RE: WDFW Comments Merten AU-25-00003

Thank you for the opportunity to provide comments for the proposed project to classify the existing manufactured home as an accessory dwelling unit (ADU) and eventually build a new single-family residence on parcel #239433. The Washington Department of Fish and Wildlife (WDFW) is familiar with the project area and nearby critical areas. WDFW provides the following comments for your consideration prior to approval of this project or the approval of a new single-family residence on this parcel.

TO: All Staff
FROM: Public Works Plan Review Team
DATE: March 17, 2025
SUBJECT: AU-25-00003 Merten

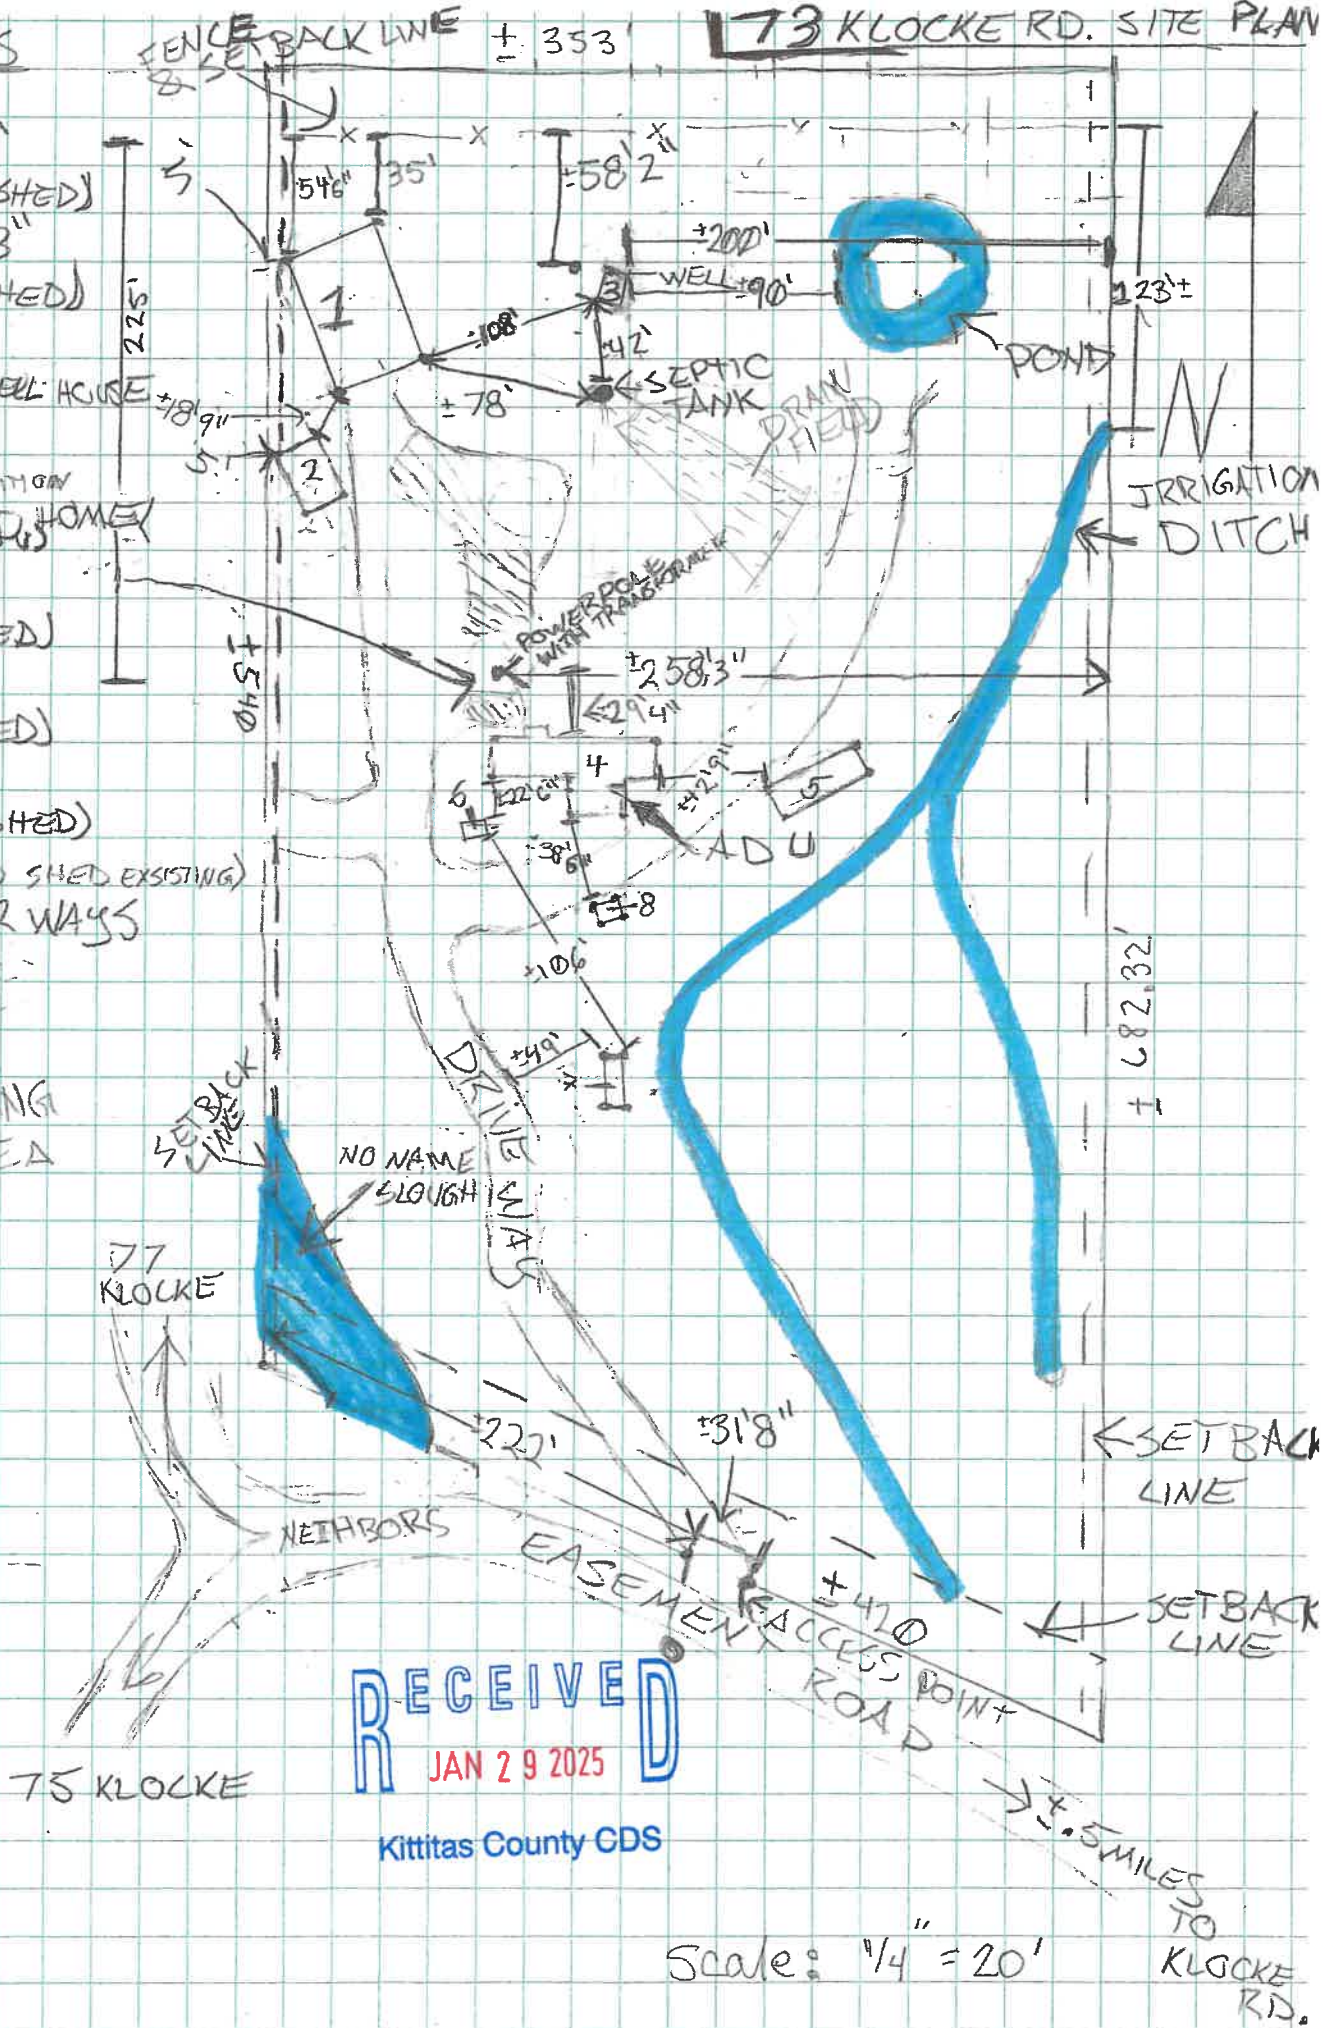
The entirety of the parcel is within the regulatory floodplain as defined by FEMA and Kittitas County. The site plan available for review shows a "No Name Slough" near the southwest corner of the parcel. This watercourse is a modified historic channel of the Yakima River and serves as the fish bypass return path for any fish entrained from the Yakima River into the Cascade Irrigation District's canal. This channel flows into a watercourse referred to as the Holmes Side Channel, near the Yakama Nation's Sampson Coho Facility, before entering the Yakima River. This channel is fish bearing throughout and has had substantial beaver activity; warranting full protection of the Type F channel and the associated Riparian Management Zone prior to approval of the project.

The site plan also shows existing irrigation ditches along the eastern portion of the parcel. The site plan shows the termination points for these ditches, but it's unclear what watercourse these channels may terminate into. WDFW would like to better understand the surface and ground water interactions associated with these channels to determine if they are wholly artificial or if they are modified natural floodplain features that warrant critical area protections. WDFW requests a site visit with the applicant and Kittitas County to better understand these water courses and what impact the proposed project may or may not have on Fish and Wildlife Habitat Conservation Areas.

WDFW recommends that a full critical areas report be completed and that we have the opportunity to review the report prior to approval of this project or the approval of a new single-family residence and the associated septic tank to ensure the proposed building site will be consistent with Kittitas County's Critical Areas Ordinance and there will be no need for variances or reasonable use exemptions for the additional proposed developments on this property. WDFW looks forward to working with the applicants and County staff to avoid impacts to critical areas

# AU-25-00003 Merten Critical Areas

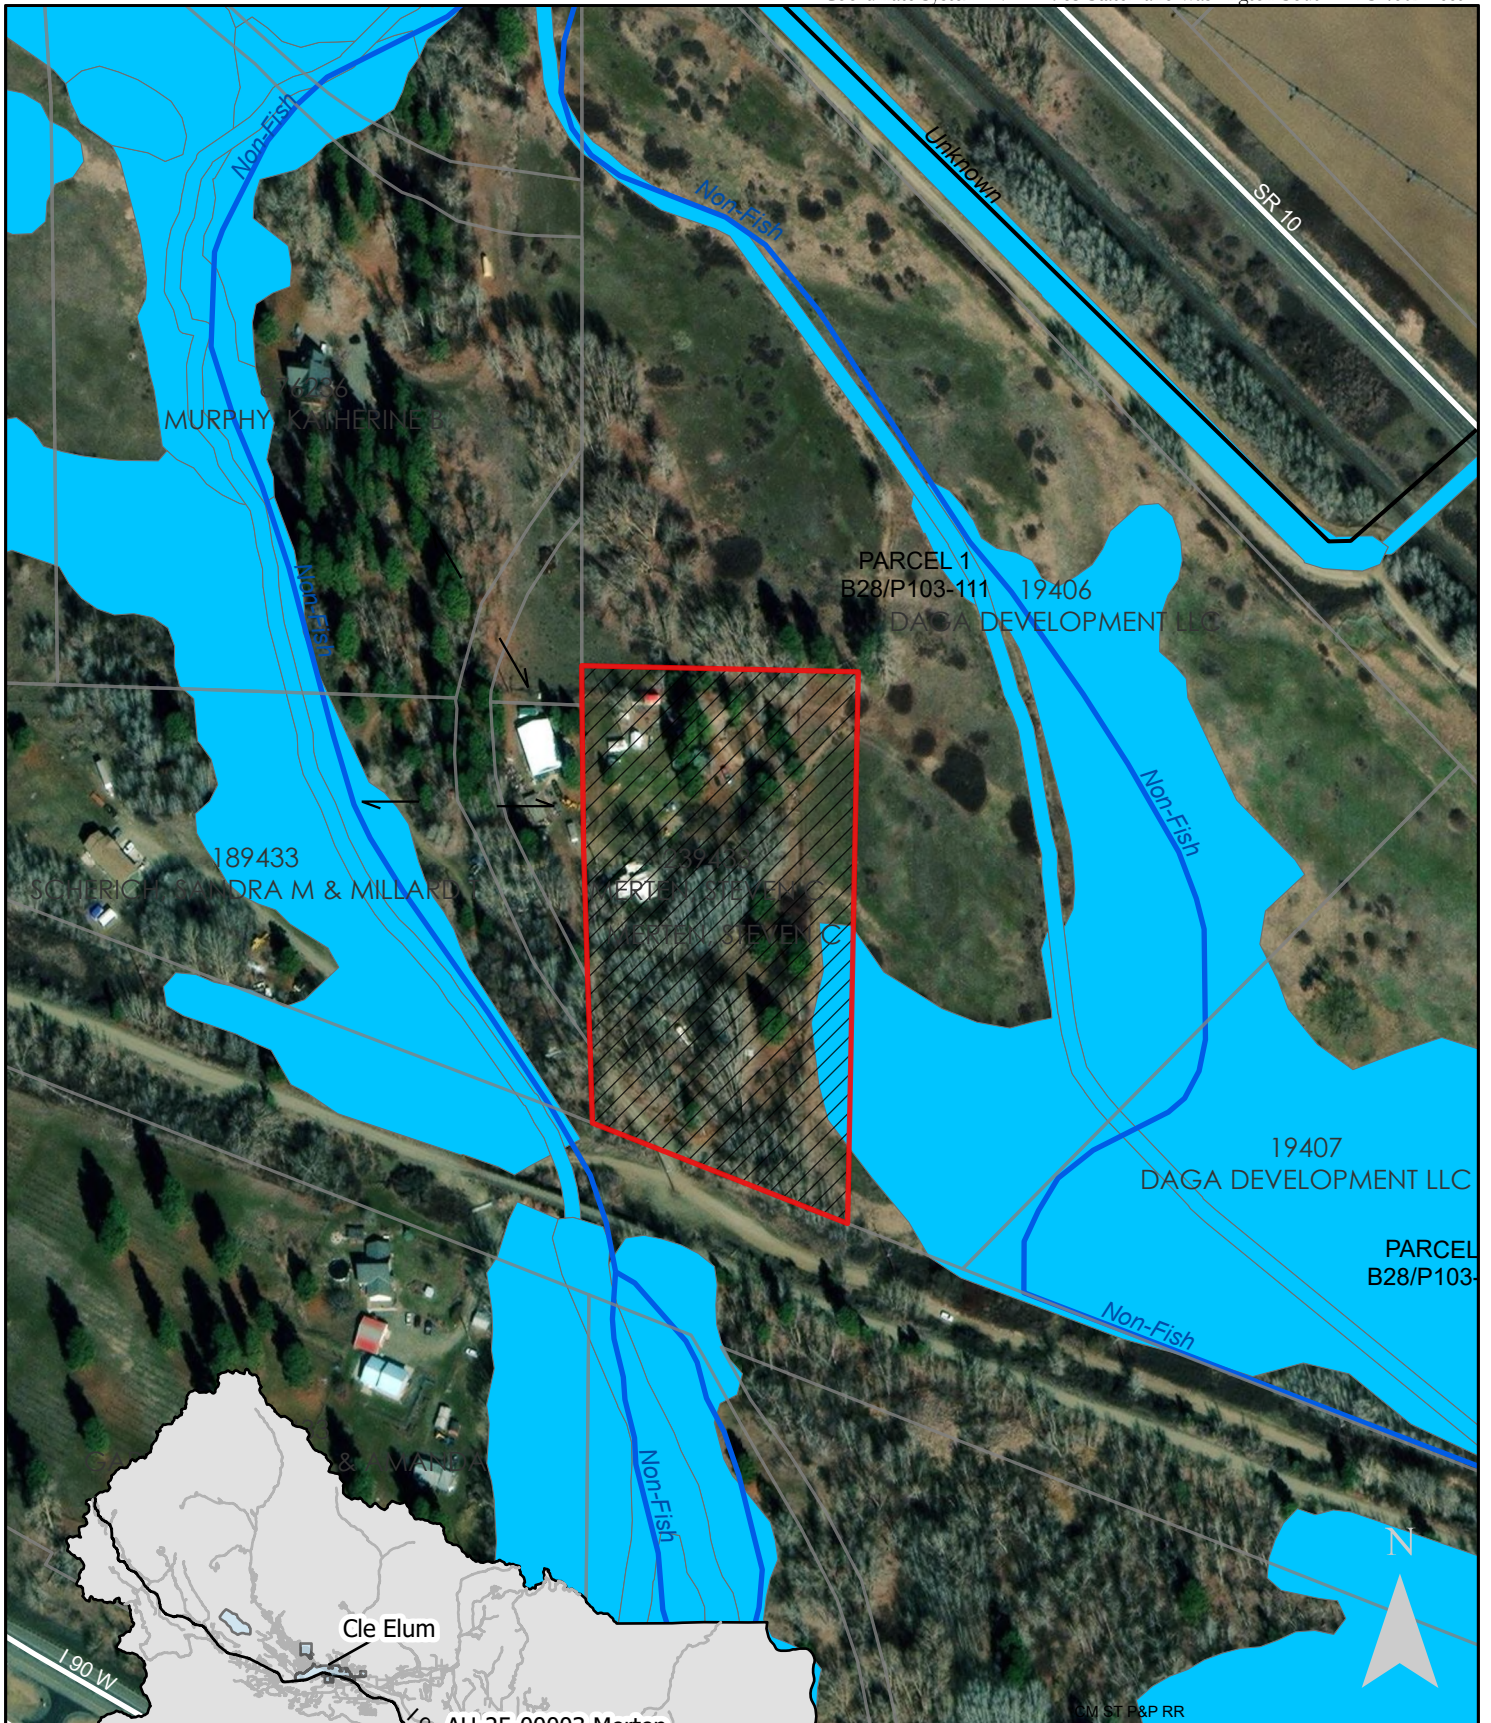
The National Wetland Inventory identifies potential wetlands near the property. Riverine wetlands provide important habitat for numerous fish and wildlife species, and they are a priority

habitat within WDFW's Priority Habitat and Species (PHS) program. Even if there are no wetlands on this parcel, it is likely the buffers for nearby wetlands may extend onto the parcel.
